Application by Rosefield Energyfarm Limited for an order granting development consent for the Rosefield Solar Farm project

Issue Specific Hearing 1

Action points

EN010158/APP/6.3.4

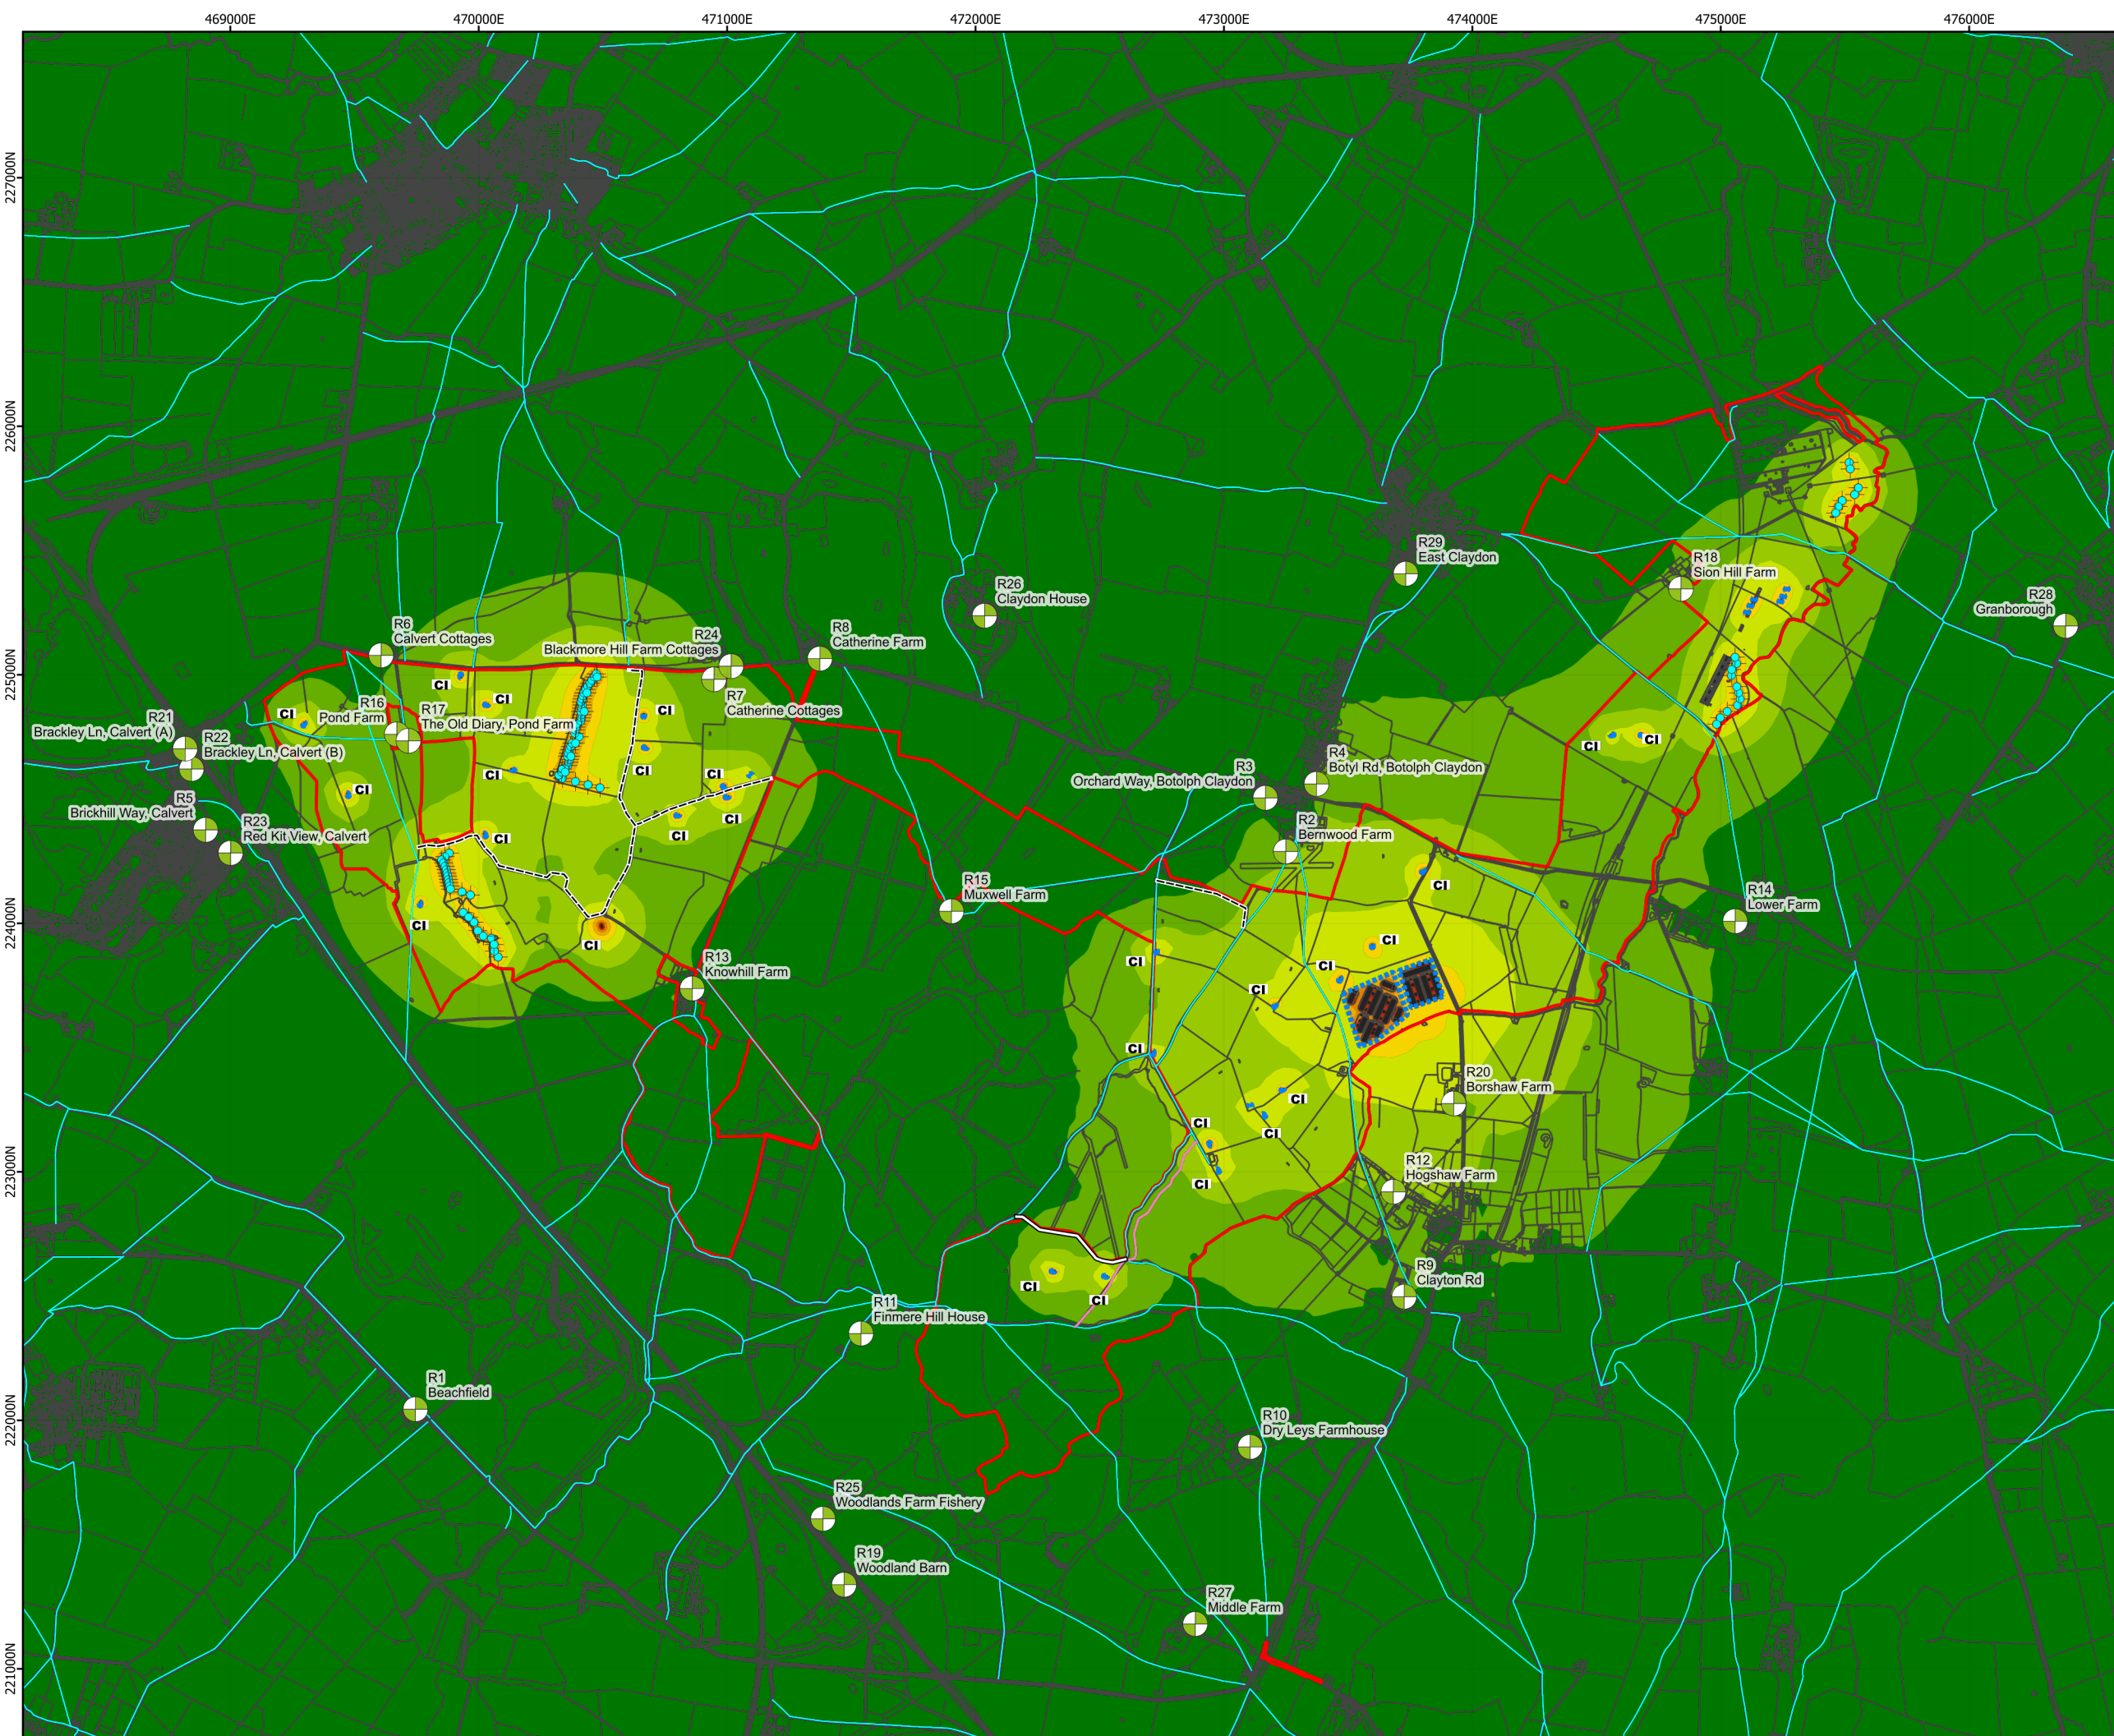
No	Party	Action	Deadline
Agenda Item 10 – Noise and vibration			
39	Applicant	To provide a technical note on its position on noise and vibration with respect to piling and substantiate why it would not exceed the relevant threshold criteria.	4
40	Applicant	To update its noise contour figures to identify the central inverter.	3
41	Applicant	To clarify how it considered noise in relation to Permissive Paths. For deadline 4, applicant to provide any additional management measures and updated plans in response to its review, as and if needed.	3
42	Applicant	To signpost its application for at-source noise mitigation during construction and how this has formed part of its assessment.	3
43	Preston Farms/ TCS Biosciences	To provide evidence of how noise and vibration effects impact the quality of donor livestock blood and consequentially, the product of its business.	4
44	Preston Farms/ TCS Biosciences	To provide (if preferable on a without prejudice basis) a response to the applicant's proposed mitigations, and identification of any further mitigations Preston Farms/ TCS Biosciences consider appropriate.	3
